Ref: 25E/3549/07

**RE: SUPPLEMENTARY REPORT ON NORTH WALL TO FARMHOUSE**

Further to my Structural Appraisal Report dated January 2025, I would confirm that an accurate electronic dimensional survey of the north elevation has been undertaken to identify the extent of lateral deformation which has occurred to the wall. 5No sections through the wall have been prepared to show the extent of lateral deformation which has occurred. This is identified in the attached drawing.

north elevation

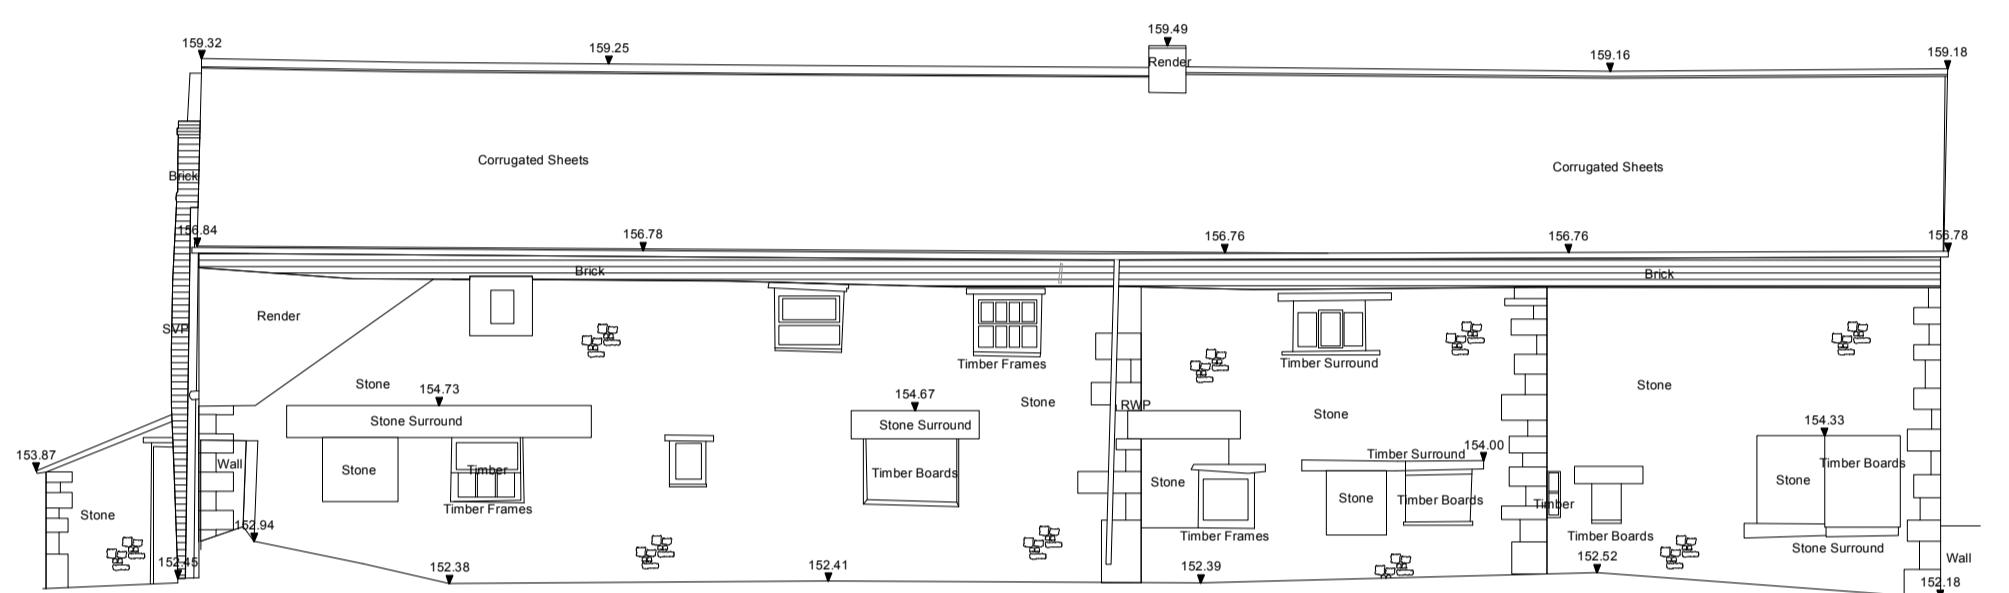
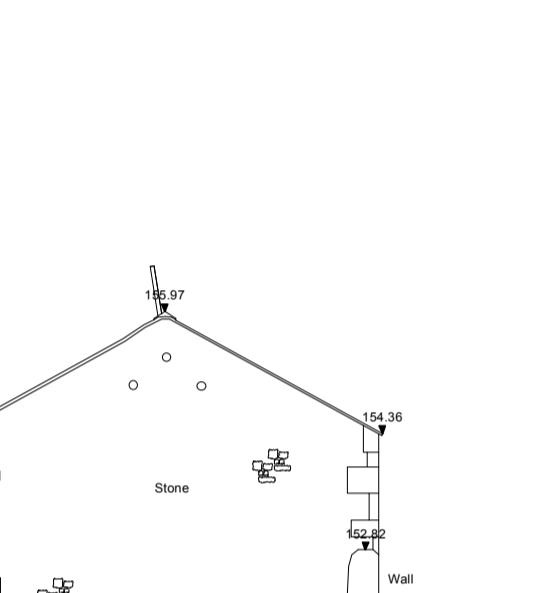
1. Lateral deformation of 68mm with an overall thickness of 478mm.
2. Lateral deformation of 162mm with an overall thickness of 714mm.
3. Lateral deformation of 129mm with an overall thickness of 818mm.
4. Lateral deformation of 197mm with an overall thickness of 806mm
5. Lateral deformation of 164mm with an overall thickness of 704mm.

The survey has identified that the thinnest part of the wall with a minimal deformation of 68mm was 478mm. The construction of the wall is likely to incorporate two leaves of solid stone, likely in the region of 150-225mm with through stones tying the two leaves together and with a rubble stone cavity/core.

For a wall to be stable, the extent of deformation is required to be within the middle third of the overall thickness of the wall, subsequently for a wall of 410mm the allowable lateral deformation would be 68mm and for a wall of 550mm thick the allowable extremity of deformation would be 92mm. The thickness of the wall measured is between 478mm and 818mm, this suggests that the outer leaf has bowed to such an extent that the cavity has increased to possibly in excess of 300mm. With a projection of 197mm with a thickness of 806mm the extent of lateral deformation is well outside of what is considered to be acceptable stability. Considering such extensive deformation, strapping or tying of the walls back to the floor is unsuitable and it would therefore be necessary for the whole of the wall to be taken down and rebuilt.
